August 20th, 2023

**Responses to City Review Comments Dated June 5th, 2023
Cui Preliminary Short Plat
SUB22 – 009**

Date:	08 / 20 / 2023
Stamp is not valid unless signed and dated	
Job Number:	220520 - PLE - 2211
DWG Date:	08 / 20 / 2023
Sheet No.	C - 5.0
	OF
	C - 7.0

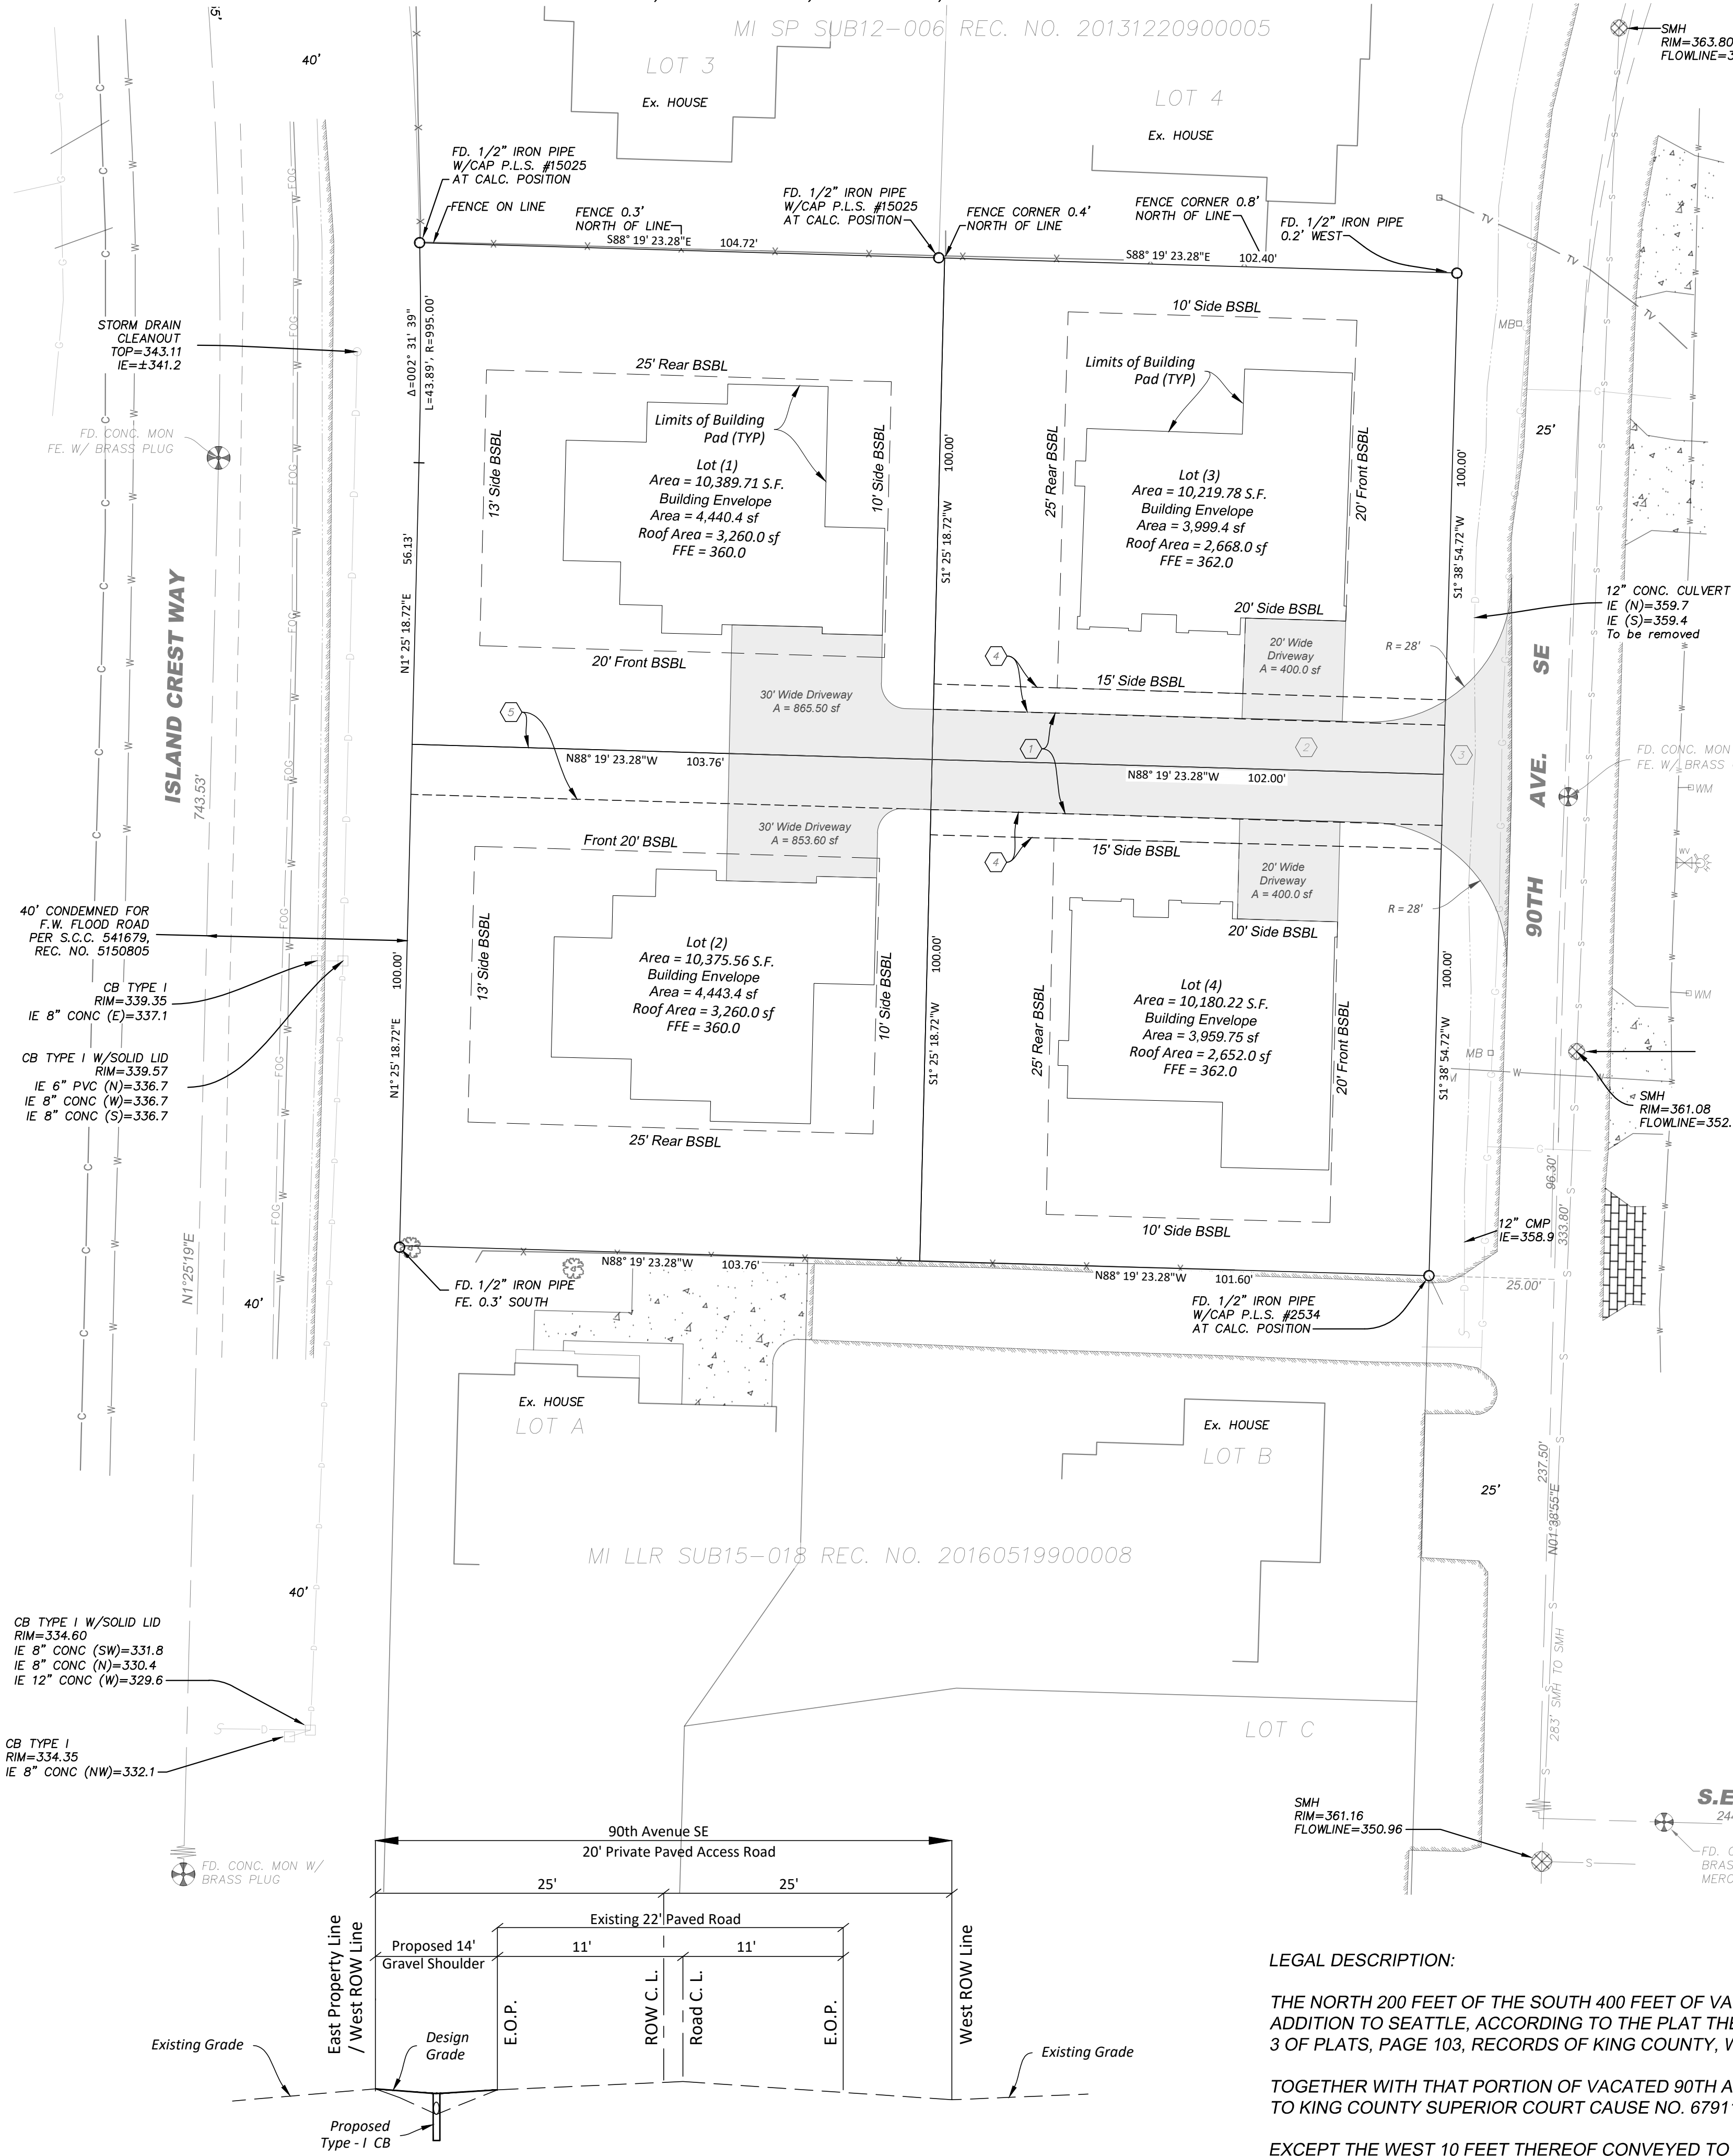
1. Add the following note to the face of the plat:

“All building permits are subject to meeting current fire code requirements at the time of a complete

submittal, including fire apparatus access as outlined in adopted code sections of the International Fire Code Appendix D. Fire plan reviews will be conducted at time of building permit submittal and may require additional fire protection systems and/or additional fire prevention measures for building permit approval.”

Please note the plan sheet number has been changed, and therefore this note is now shown on Plan Sheet C – 4.0

Sheet No.
C - 6.0
C - 7.0

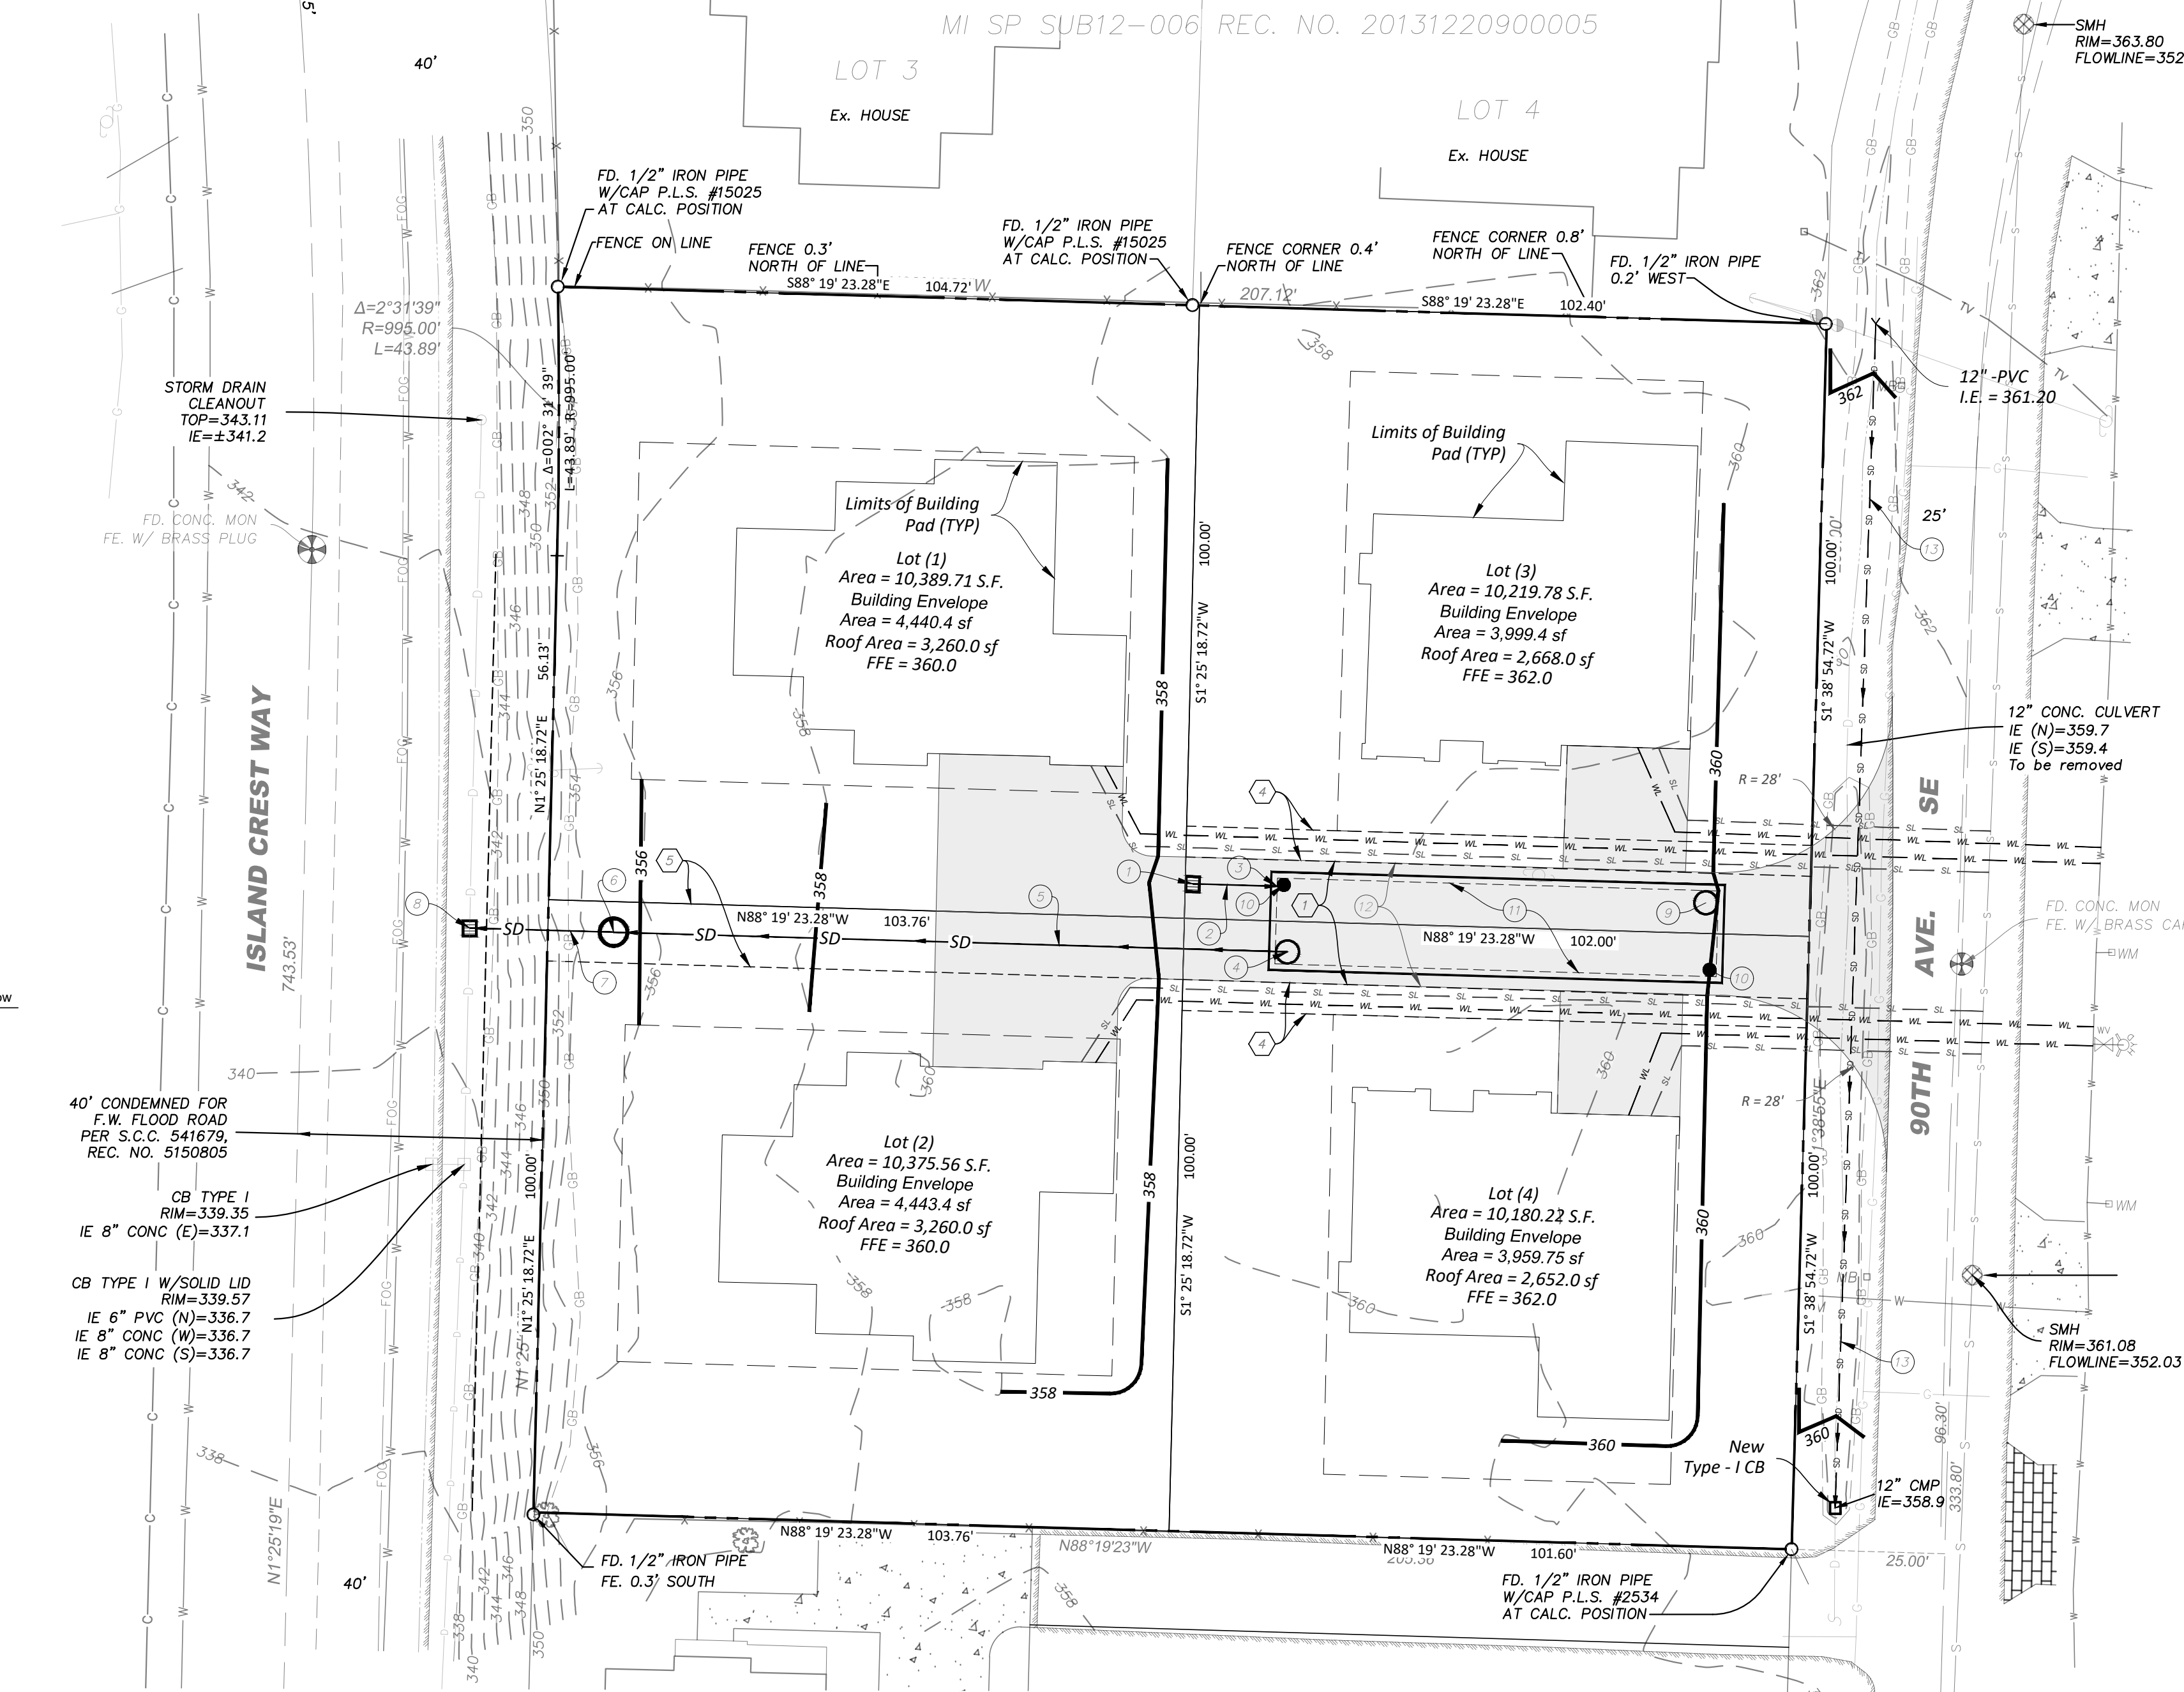
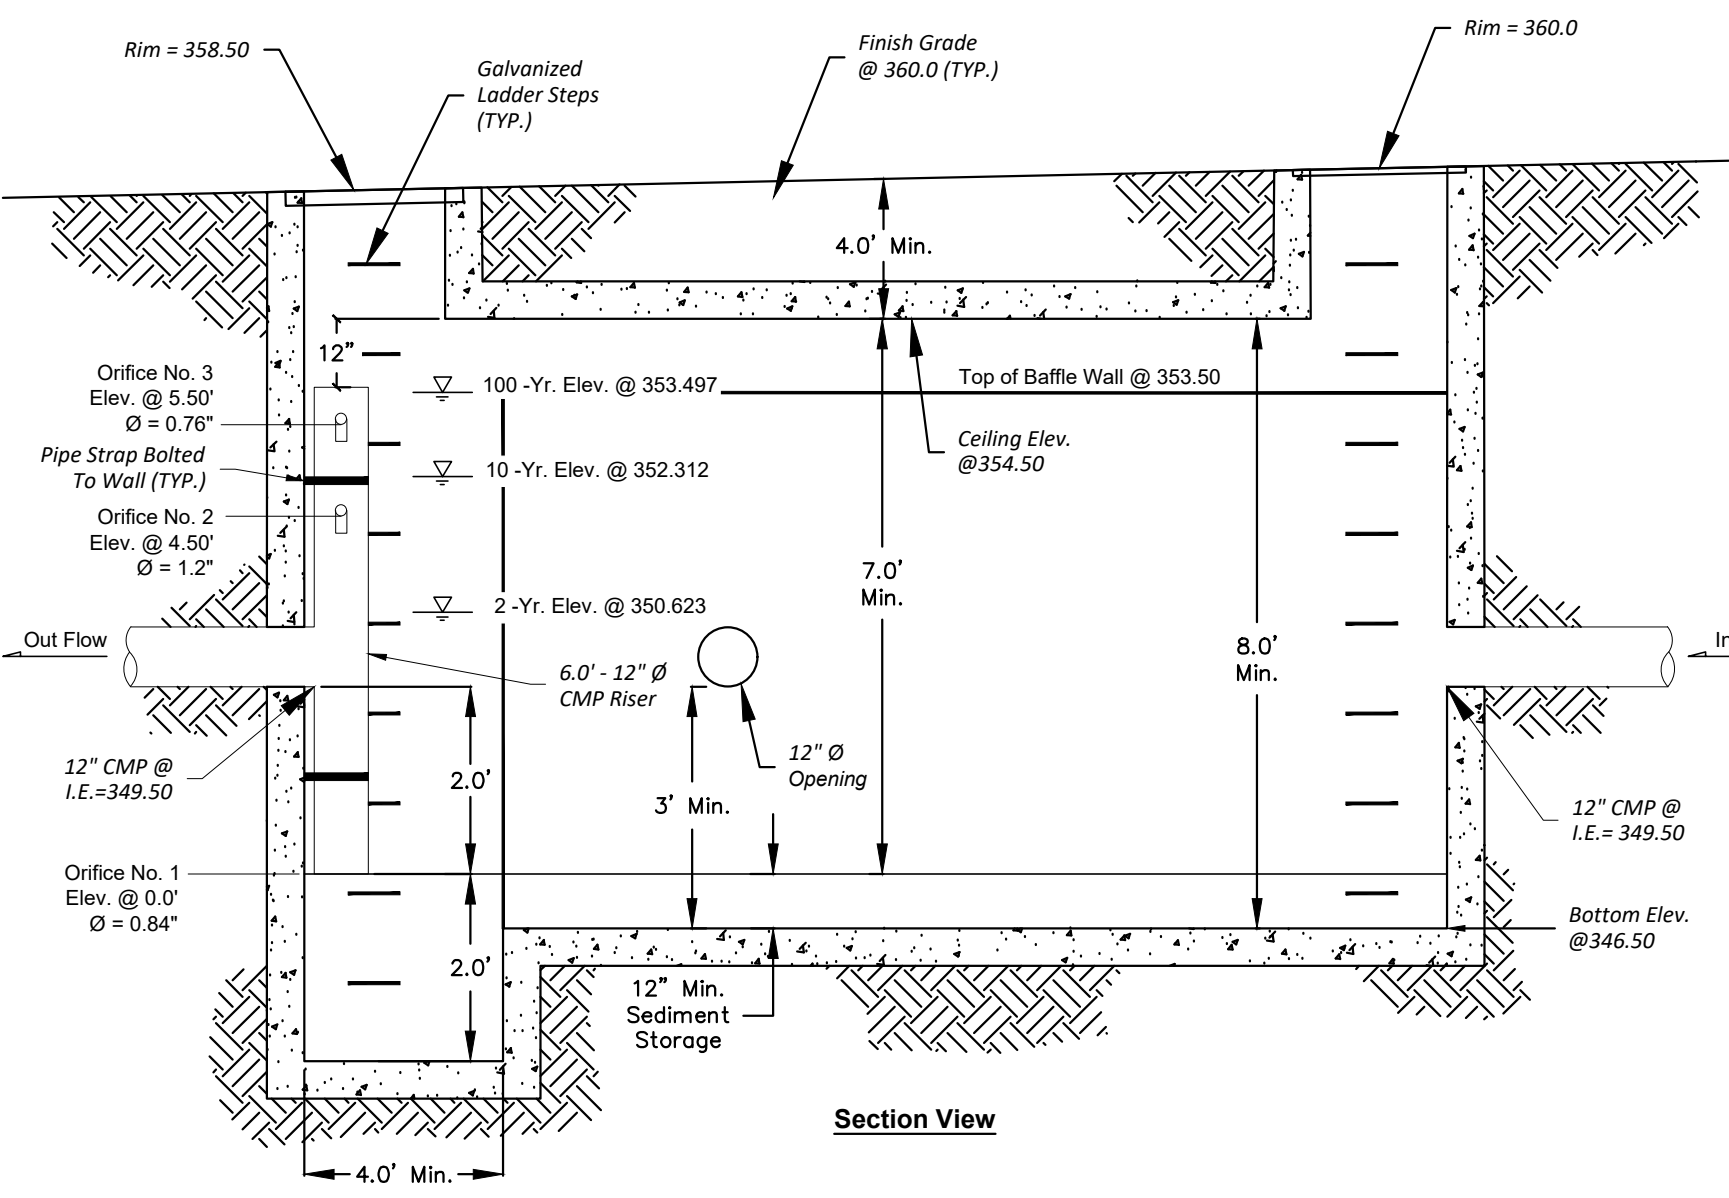
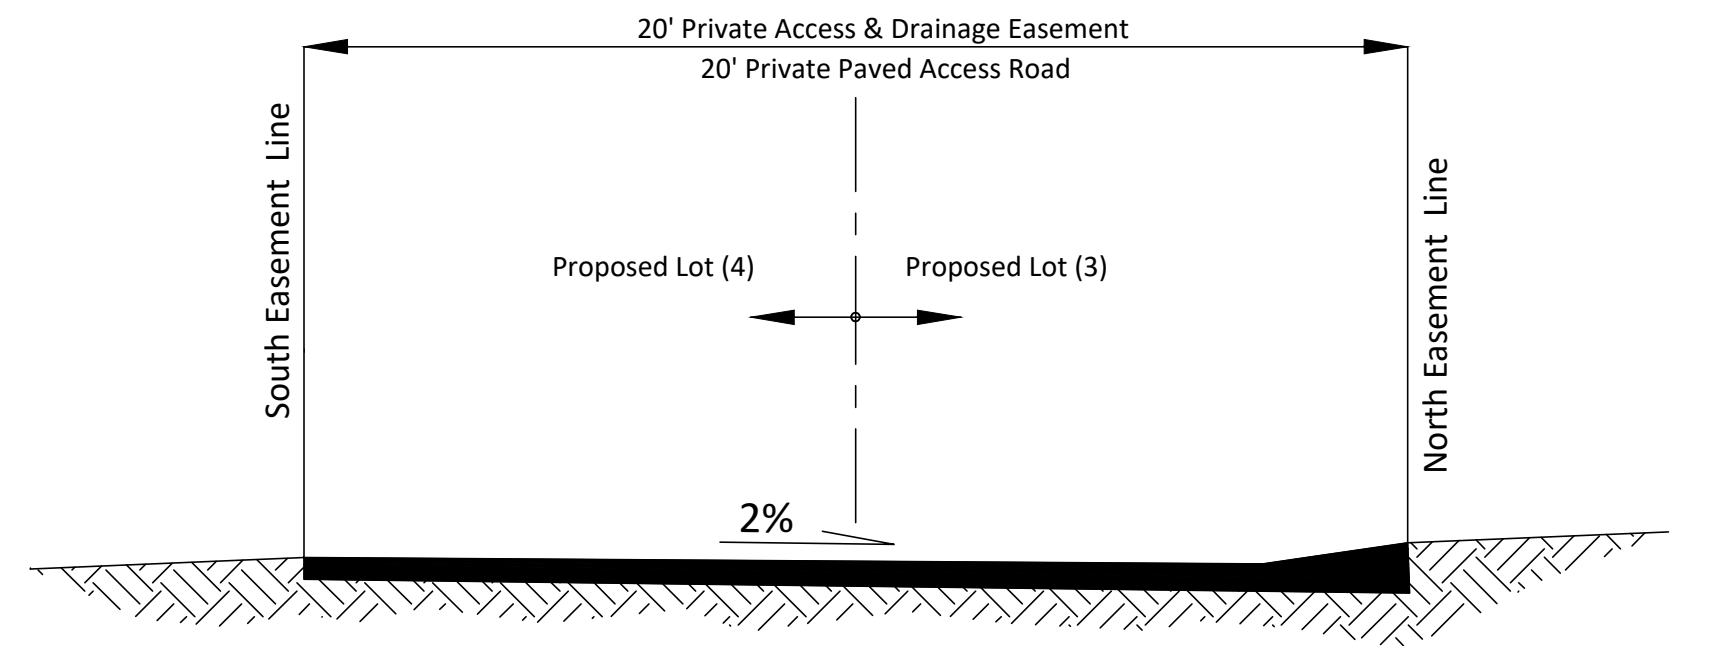
As shown on the attached revised Civil Plans, Sheet C – 7.0 the proposed building pads are located in a manner that minimizes site grading work and impact to existing topography while maintaining on-site positive gravity drainage systems. The anticipated grading work within building pads is very minimal and is not expected to exceed 24" of grade cut / fill as necessary to construct the new building pads.

6. MICC 19.08.030(E)(4) and MICC 19.09.100(A) require development proposals to use common utility corridors where feasible. The site plan shows that each of the lots of the proposed short subdivision will have its own utility corridor. Revise the location of the utilities so they use a common utility corridor. Alternatively, provide documentation showing how using a common utility corridor is infeasible for this proposal.

3. The existing drainage ditch along the frontage of 90th Ave SE shall be piped as a part of the plat improvements.

4. Add the following note to Sheet C-6.0:

“The utility design (water, sewer, and storm) shown on Sheet C-6.0 is conceptual only. The basic layout and conceptual design of the utility design will be reviewed under this short plat application. The detailed design has not been reviewed for construction. All design related to water, sewer, storm and roadway are not approved and will be reviewed under a separate permit.”

The attached revised Civil Plans Sheet C – 7.0 will show one utilities corridor under the proposed on-site access road within proposed utilities easements along the frontage of each proposed lot.

The attached revised Civil Plans Sheet C – 7.0 will show stormwater pipes in said ditch as requested by the city.

Please note the plan sheet number has been changed, and therefore this note is now shown on Plan Sheet C – 7.0
